#### FINAL DRAINAGE REPORT FOR SADDLEHORN RANCH – FILING 2 EARLY GRADING

> May 18, 2022 Project No. 25142.04

El Paso County PCD File No.: EGP221 Final Drainage Report Filing 2 - Saddlehorn Ranch Early Grading

SHEET 4.1 OF 14
JOB NO. 2514204

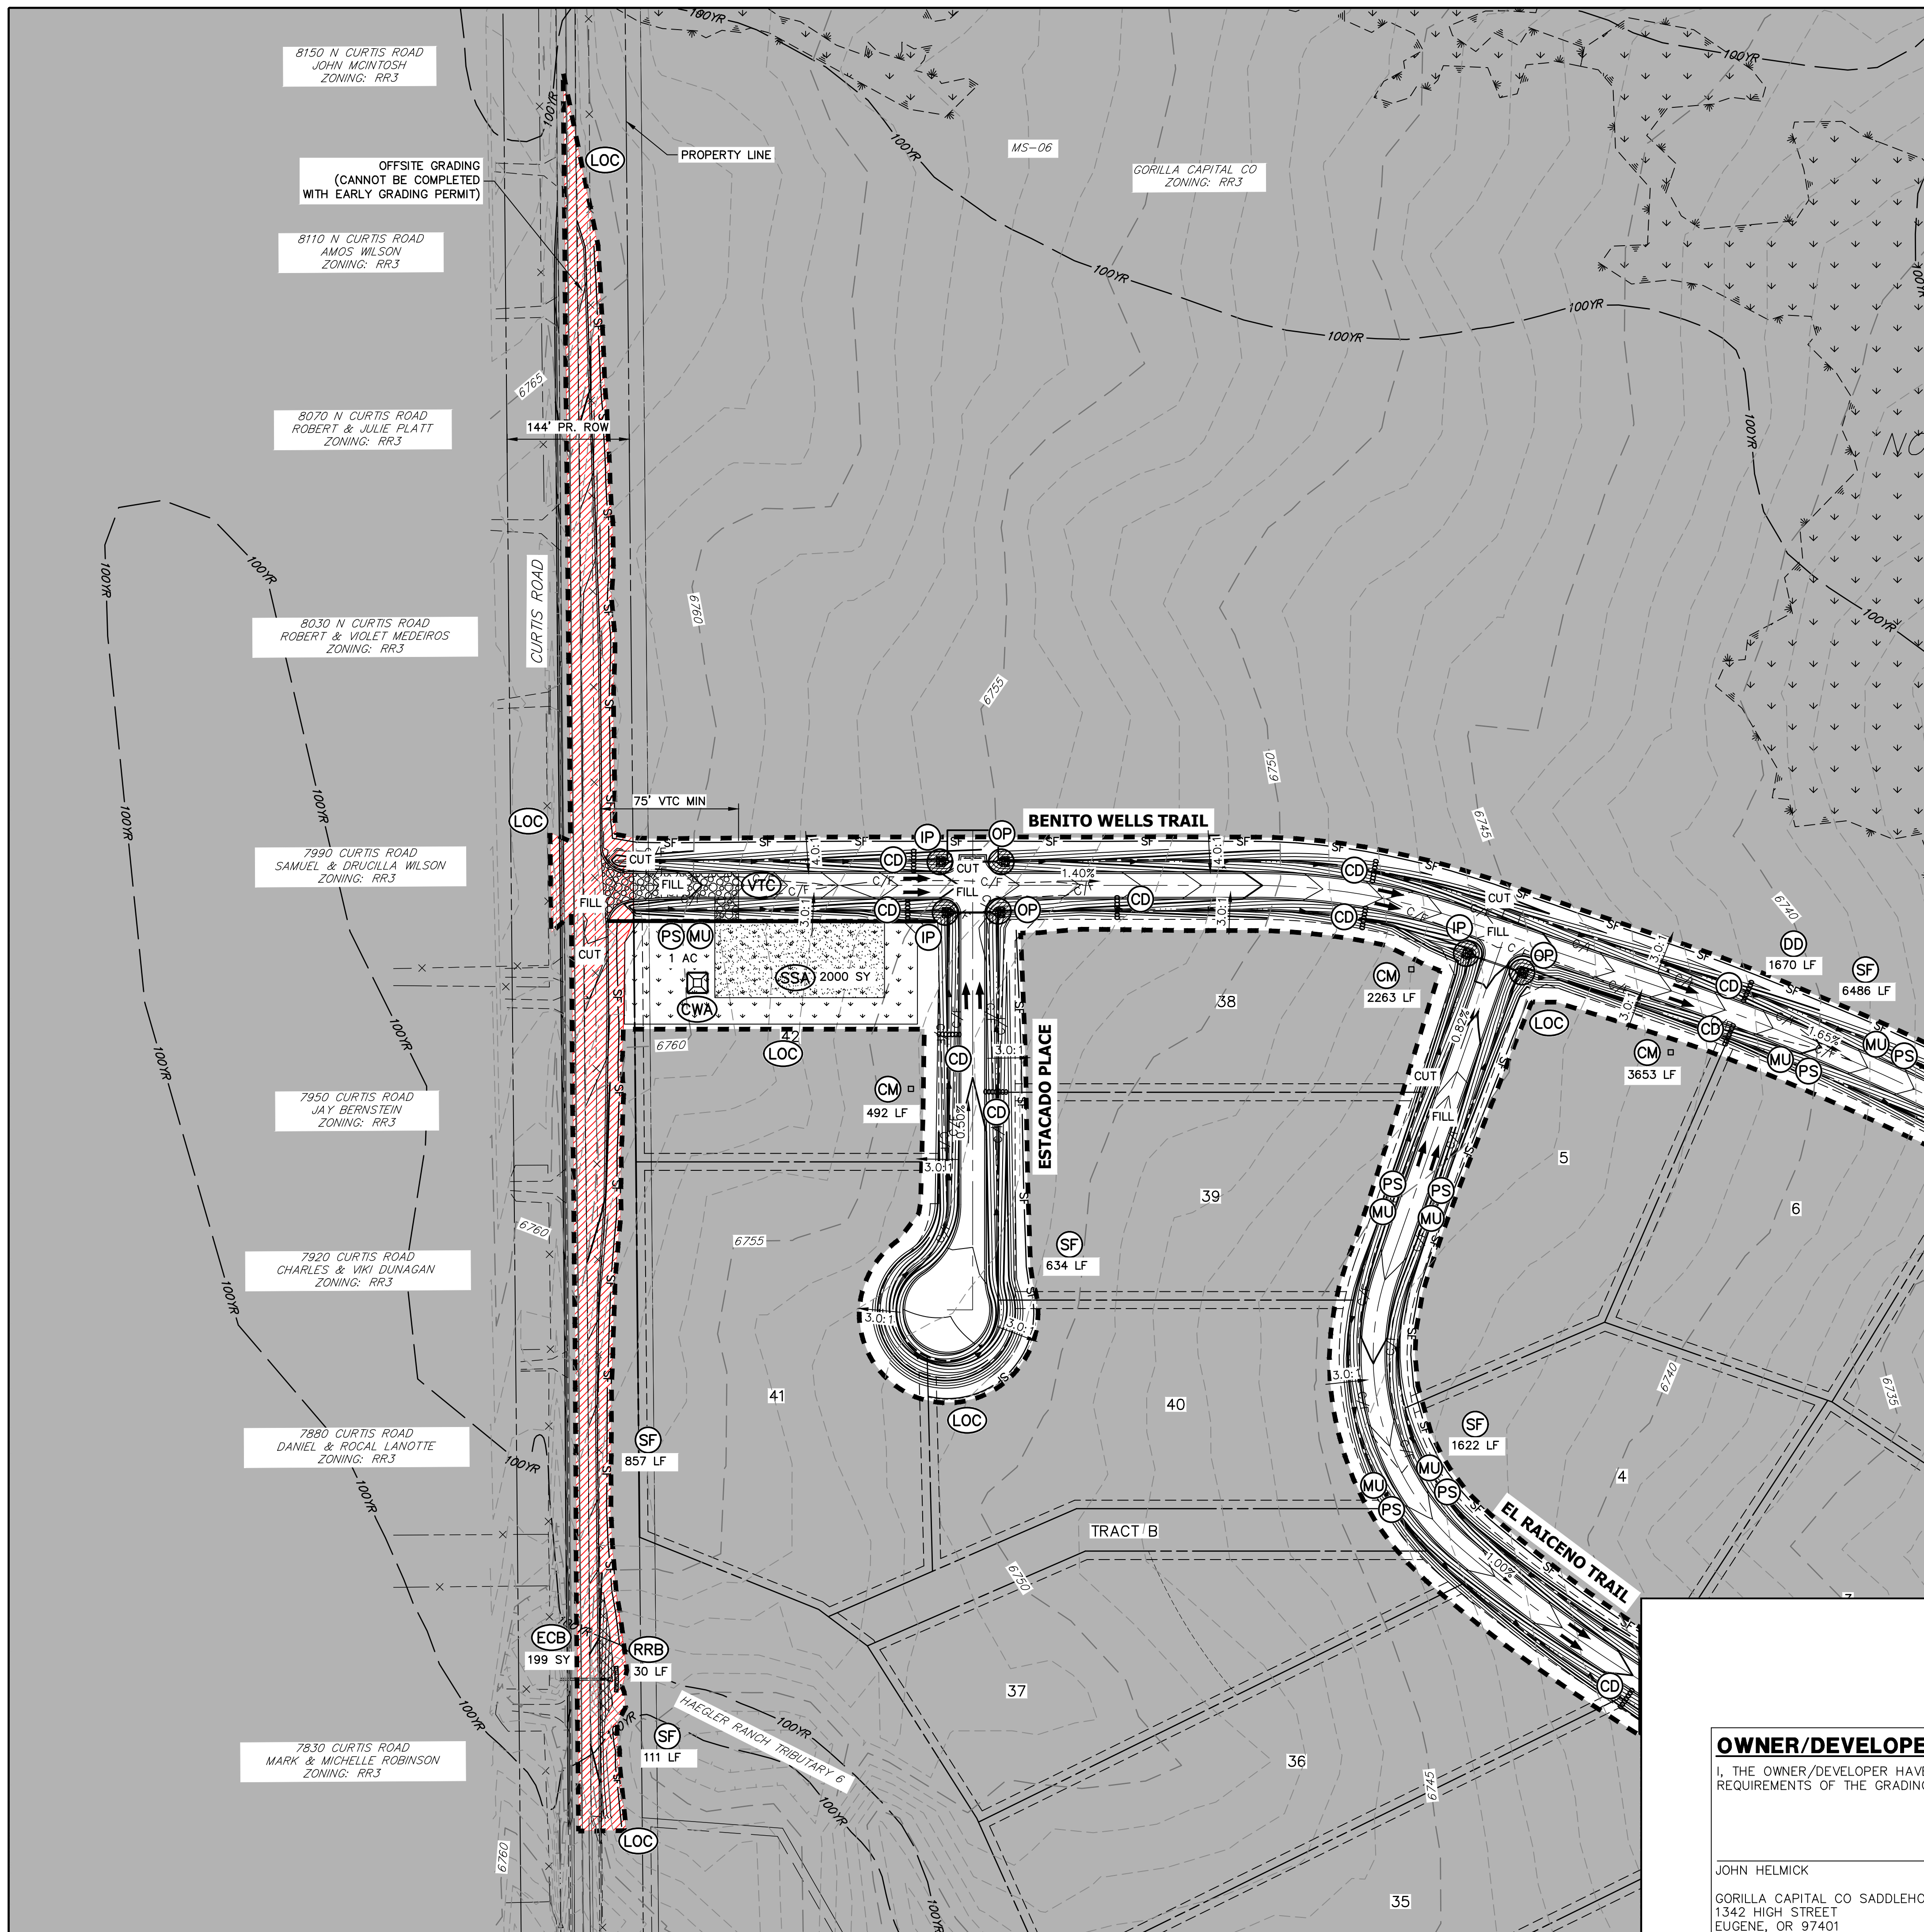
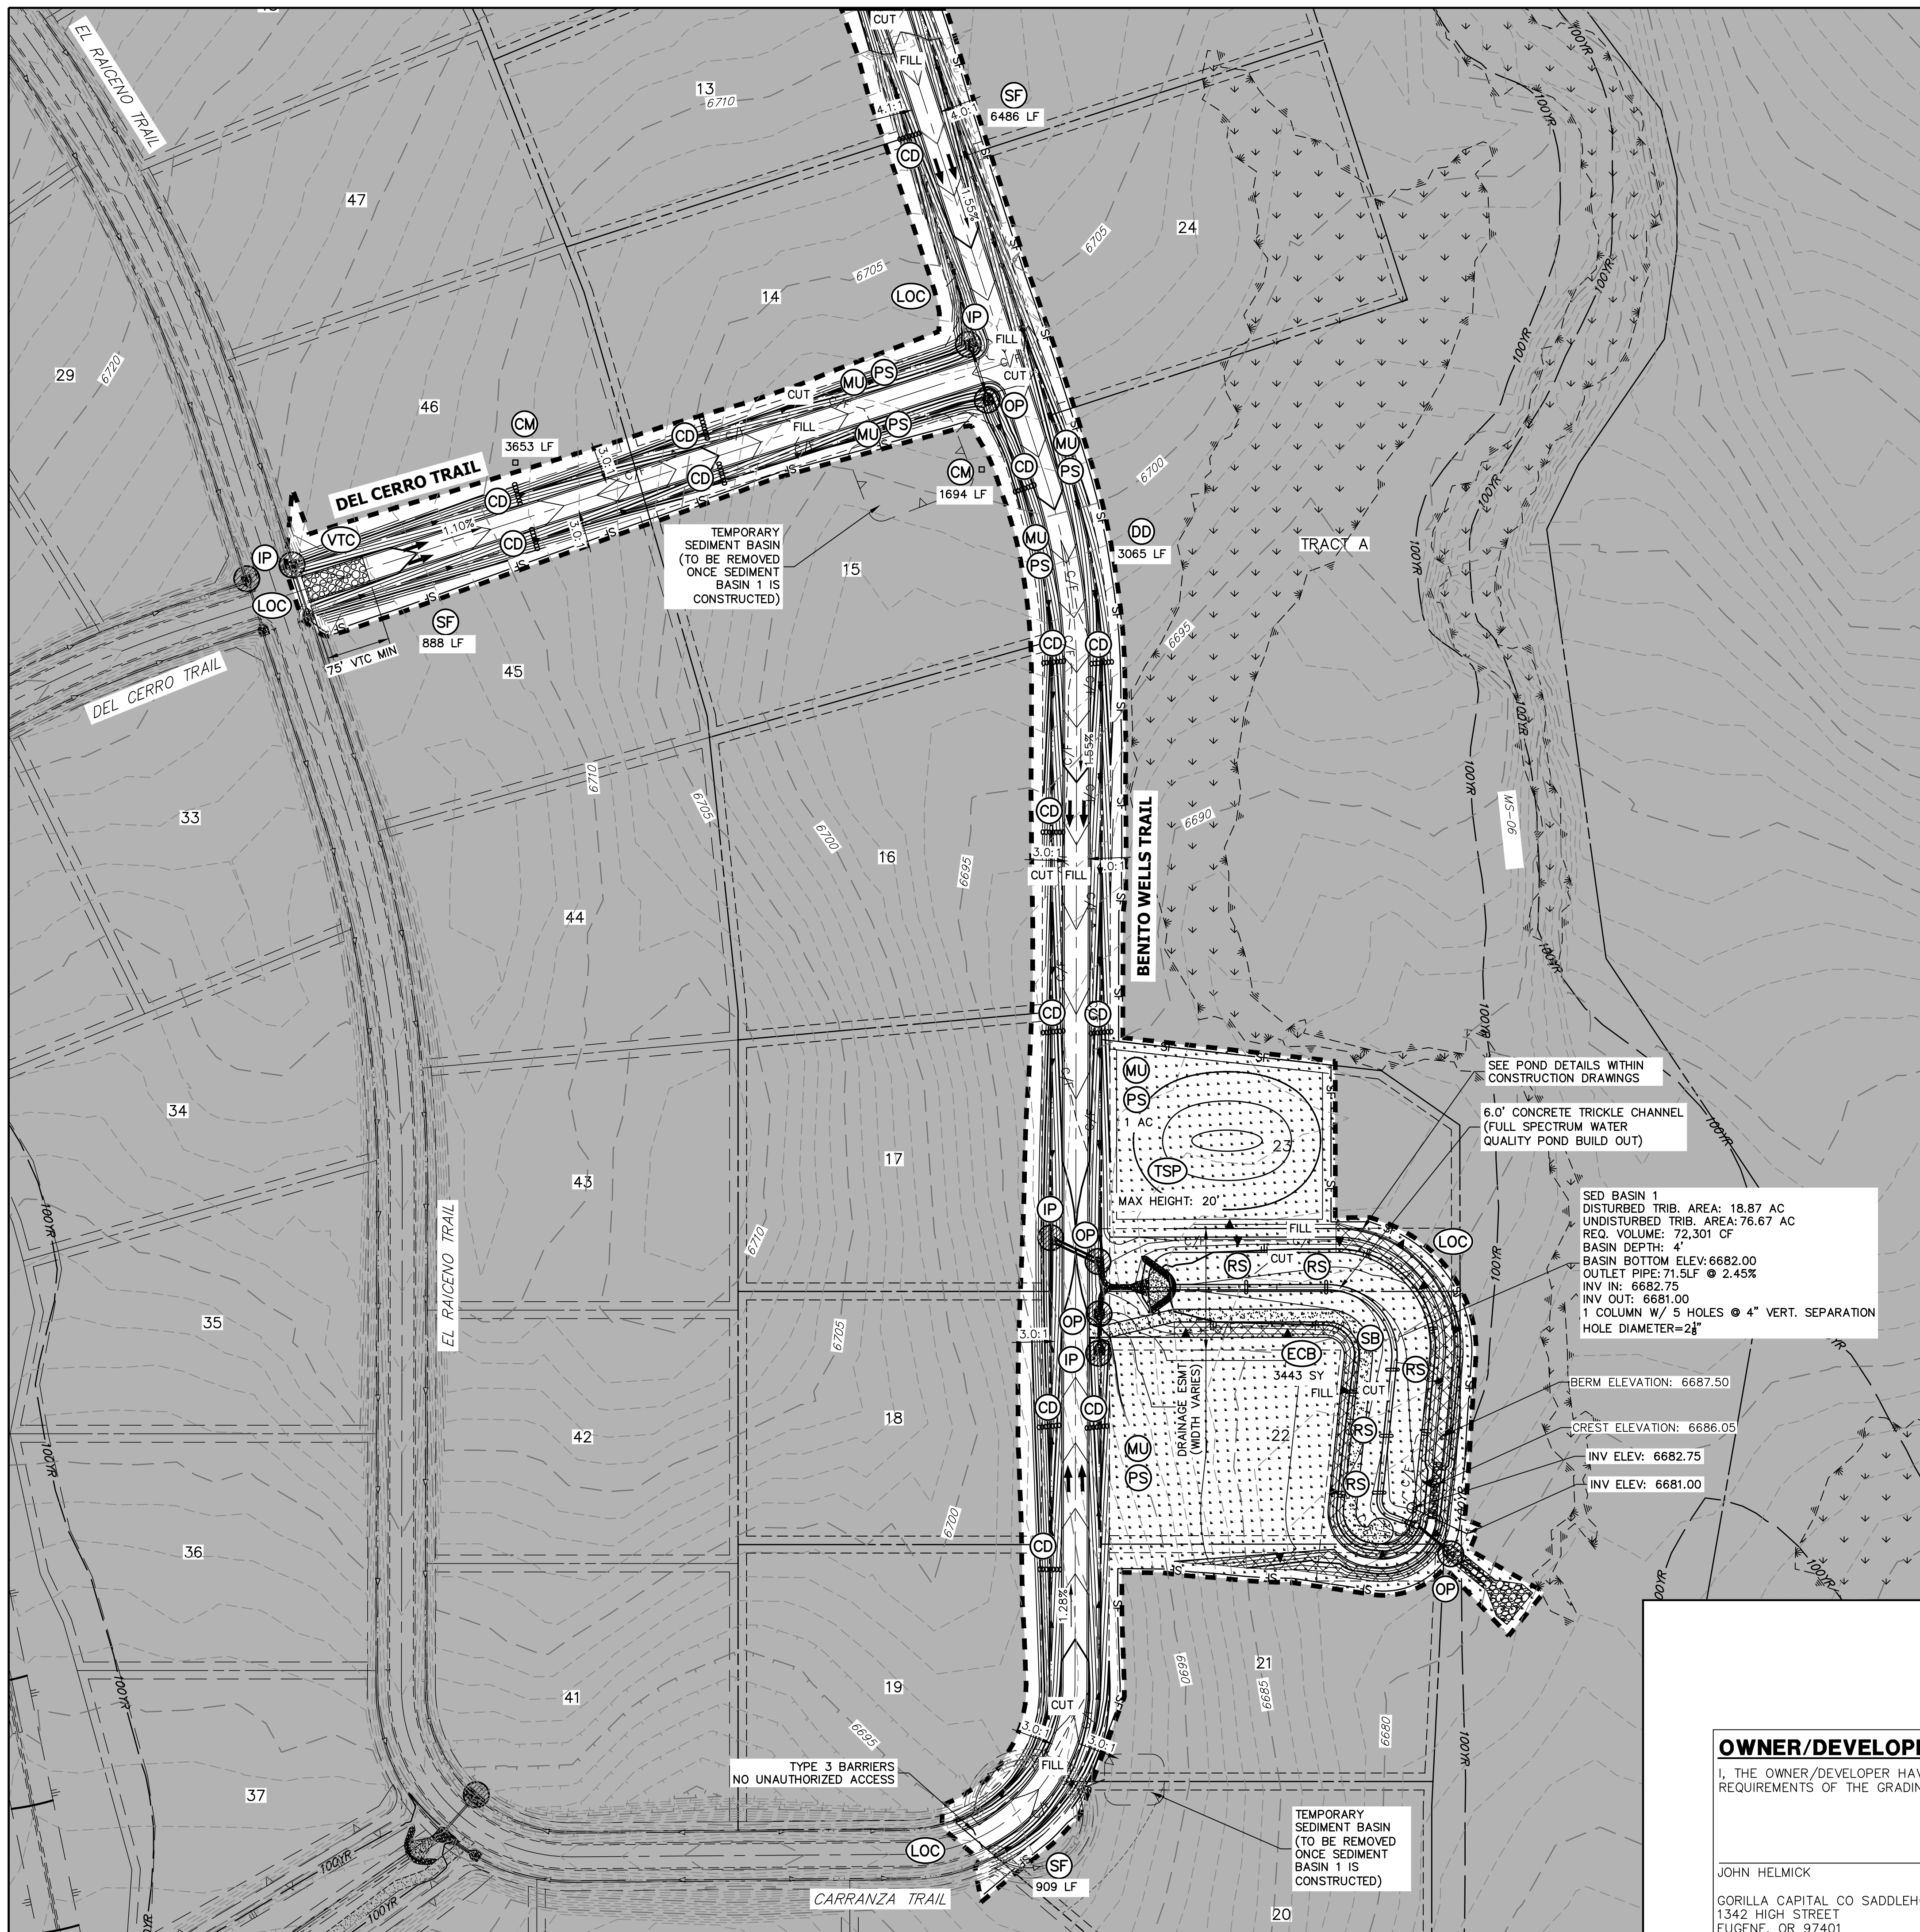
Update the narrative to describe. Is this proposed or existing? If proposed then provide construction details.

See Table 3 beld The Pre-Development GEC plan include plain the purpose of these existing basins. Pond F Emergency Spillway that appears to be for buildout condition. If this is correct then state in the narrative as such.

Additionally state whether the spreader of the pond outfall is designed to buildout or temporary condition? If to buildout then final hydraulic analysis needs to be included with this report for review and construction level detail included in the GEC plan.

Basin F runoff along with runoff from S conveyed to the proposed full spectrum water quarty and detent release treated flow at less than historic rates to minimize adverse discharge into Major Drainageway MS-06. JR: This temporary sediment basin was built with the previous filing. The labels on the GEC plans have been updated to reflect that. Additionally the narrative has been update to ex-

~ 4 4
JR: Po	ond F's foreb	ay, outfall s	preader/ripra	ap, trickle	chanr	nel, a	nd $3.0$	011
emerg	ency spillwa	y will not be	e constructed	d with sed	liment	basir	า 1	
at the	time of early	grading. Ea	ach item mei	ntioned al	bove is	s de-		
signed	I for the final	buildout co	ndition (Pon	d F) and	will be	in-		
cludec	I with the FD	R and cons	truction doc	uments. T	he de	tails	S	ub-l
have b	een remove	d from the I	Early Gradin	g GEC pl	ans to	refle	ct in	1. T
that.								orog
